Appeal Decision

Appeal Ref: APP/T2350/A/14/2219388

Land south of Oakfield, Showley Road, Clayton-le-Dale, Blackburn, BB1 9EX

- The appeal is made under section 78 of the Town and Country Planning Act 1990 against a refusal to grant planning permission.
 - The appeal is made by Mr D Hayes against the decision of Ribble Valley Borough Council.
 - The application Ref 3/2013/0448, dated 20 March 2014, was refused by notice dated 15 May 2014.
 - The development proposed is a poultry unit.
-

Proposed Site Plan

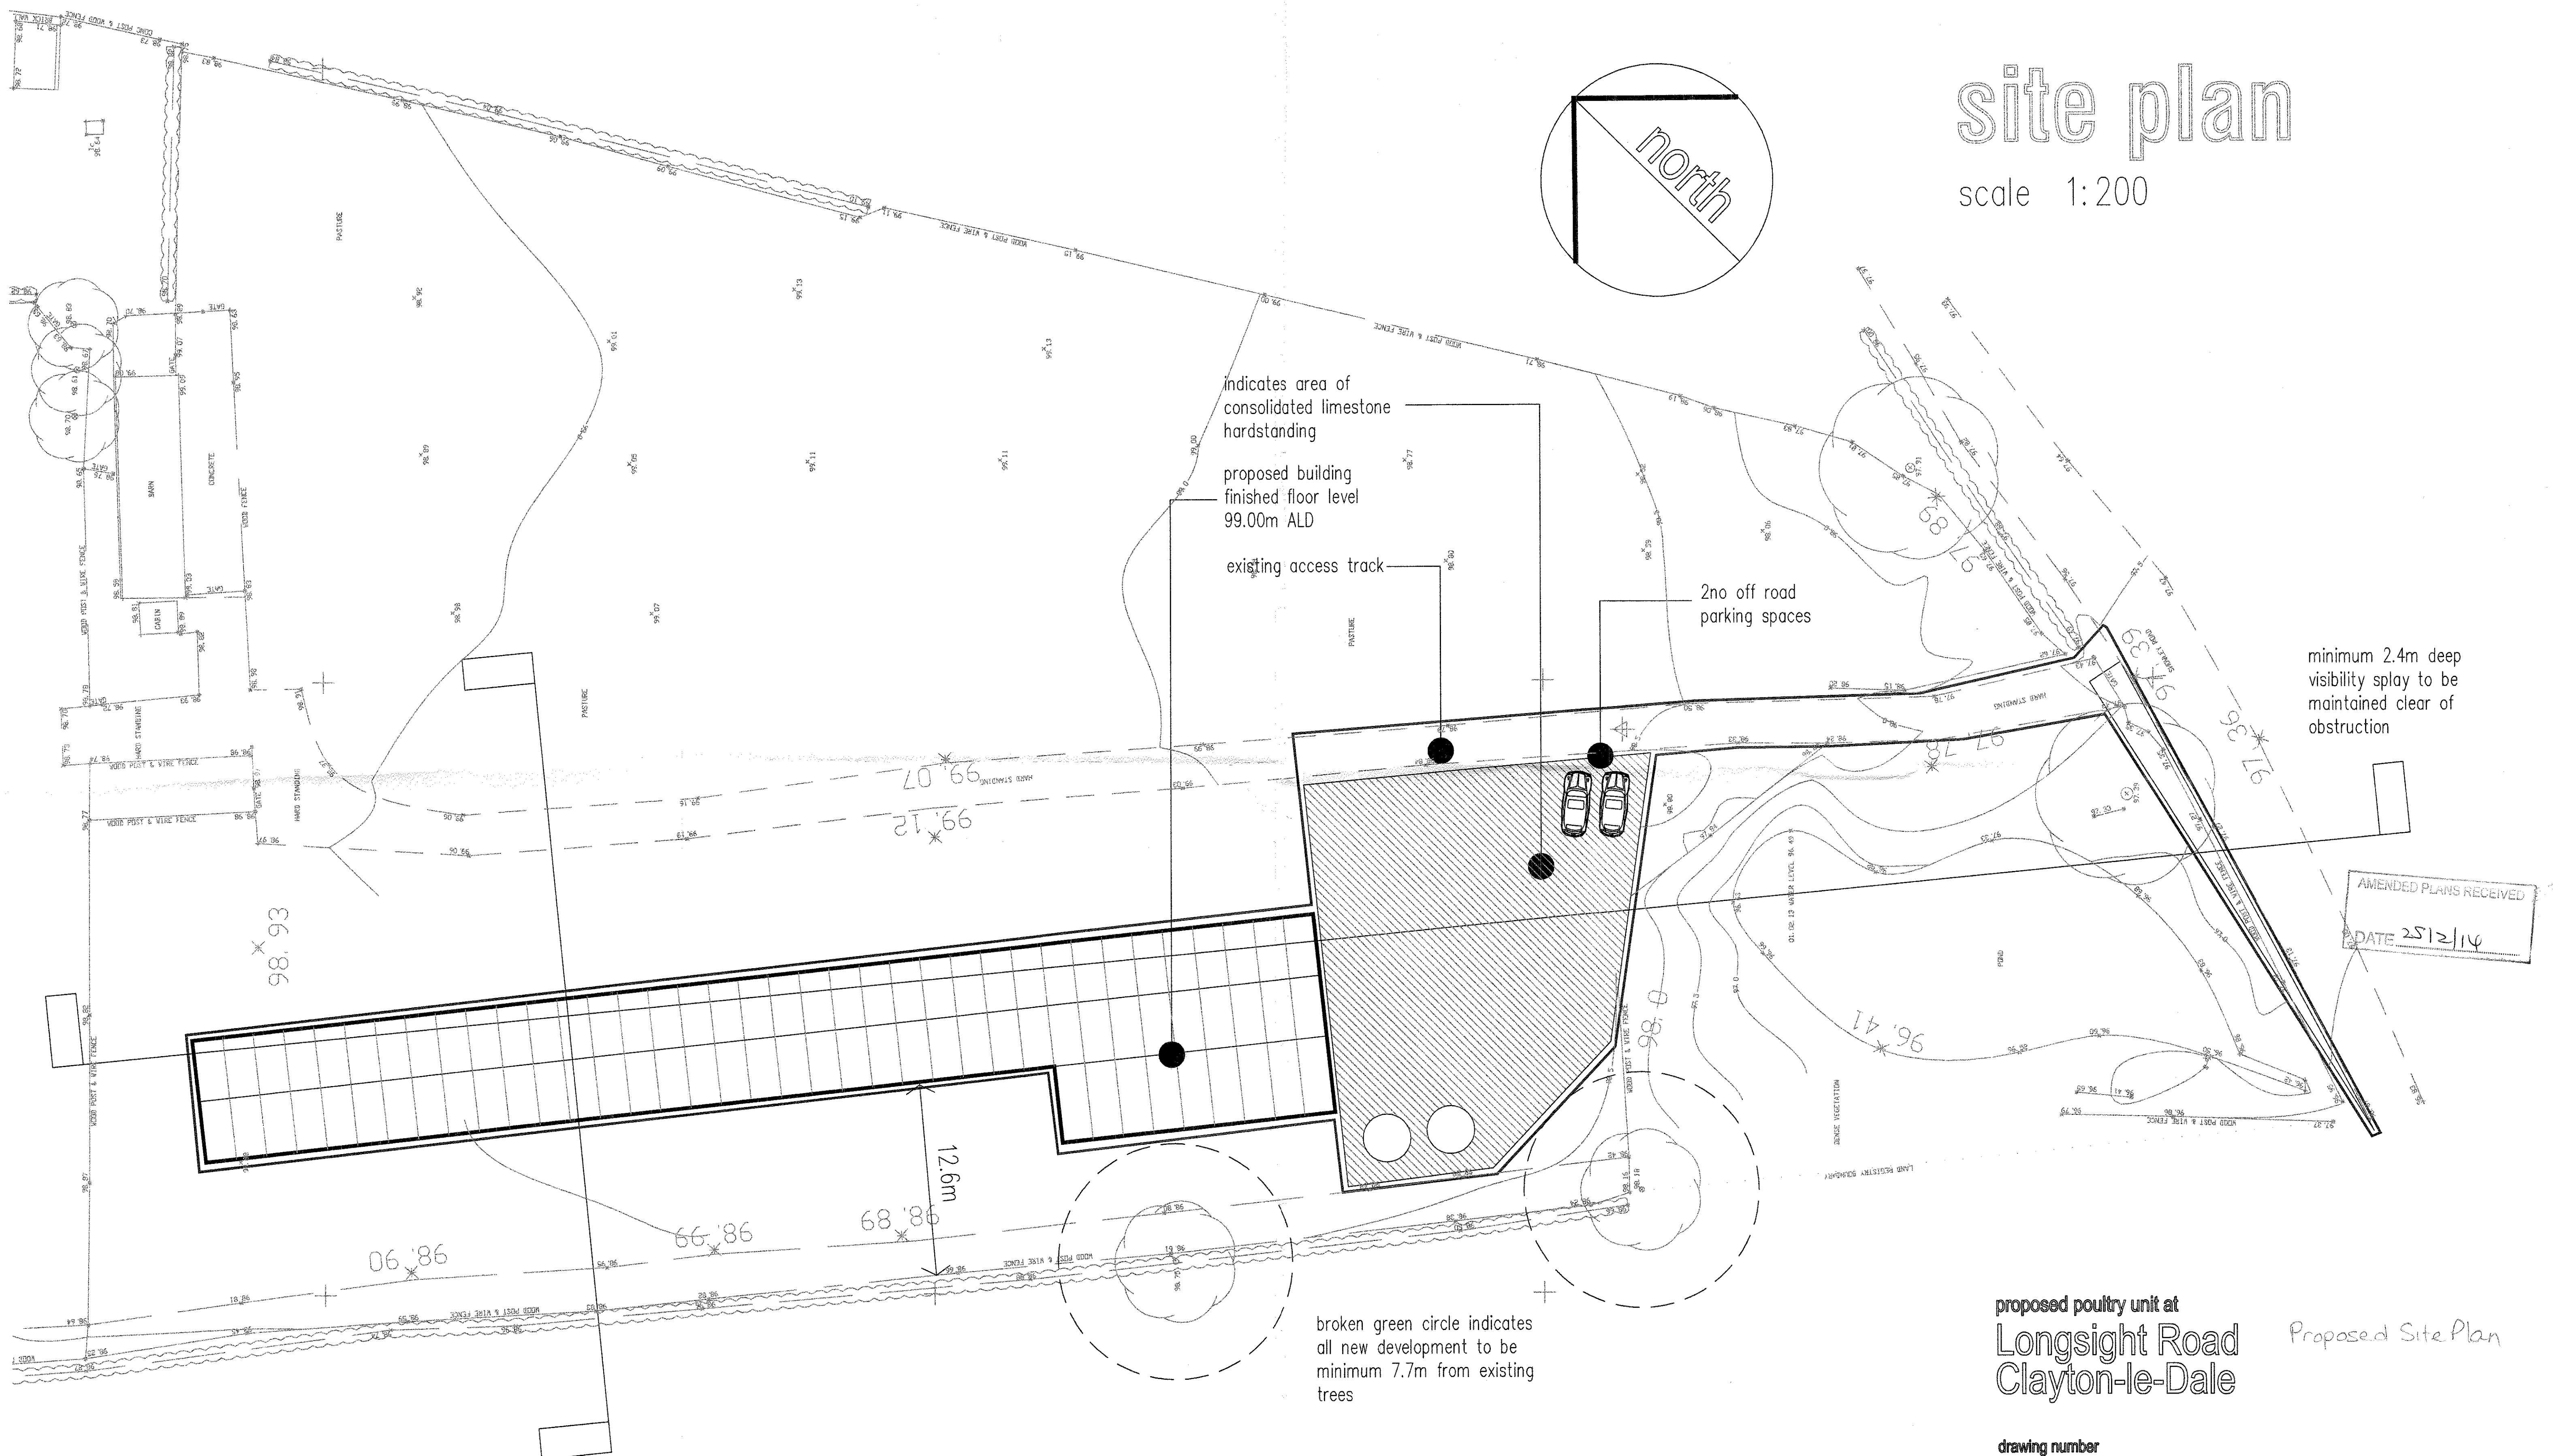
3. The red edge, which denotes the extent of the appeal site, is shown differently on the location plan and the proposed site plan. On the latter it includes a visibility splay along Showley Road and it is drawn further away from the sycamore tree near the pond. The main parties agreed that the extent of the appeal site is as shown on the site plan, and I have considered the appeal on this basis.

17. The poultry building would be erected parallel to the hedgerow which forms the south-west boundary of the field. The nearest part of the building would be about 7.7m from the hedgerow and about 6.6m from the trunk of a mature ash tree¹. The hardstanding would be about 7.7m from a sycamore tree and about 2.5m from the hedgerow. Referring to British Standard BS 5837, the Appellant calculates that the root protection area of the ash tree would have a radius of 7.2m which, in unrestricted conditions, could be reduced by up to 20% on one side, giving in this case a distance of 5.9m on the side of the proposed building. The Council does not dispute this approach. The hedgerow is more compact than the ash tree, the canopy of which spreads outwards from the field boundary, and I consider that the poultry unit would be a sufficient

¹ The distance of 6.6m is given in the Appellant's arboricultural assessment. The proposed site plan gives a somewhat greater separation distance of 7.7m between the position of the building and the ash tree.

distance to avoid any undue harm to the ash tree and the hedgerow. Similarly there should be no harmful effect on the sycamore tree, given its distance from the intended position of the hardstanding. The hardstanding would be closer to the hedgerow, but the edge of this area could be formed using a no-dig method of construction to minimise any effect on the root system. On Showley Road, hedgerow removal would be required on each side of the access to secure the visibility splays. Conditions could secure replanting behind the splays and the implementation of a scheme to protect the trees and hedgerow on the south-west field boundary.
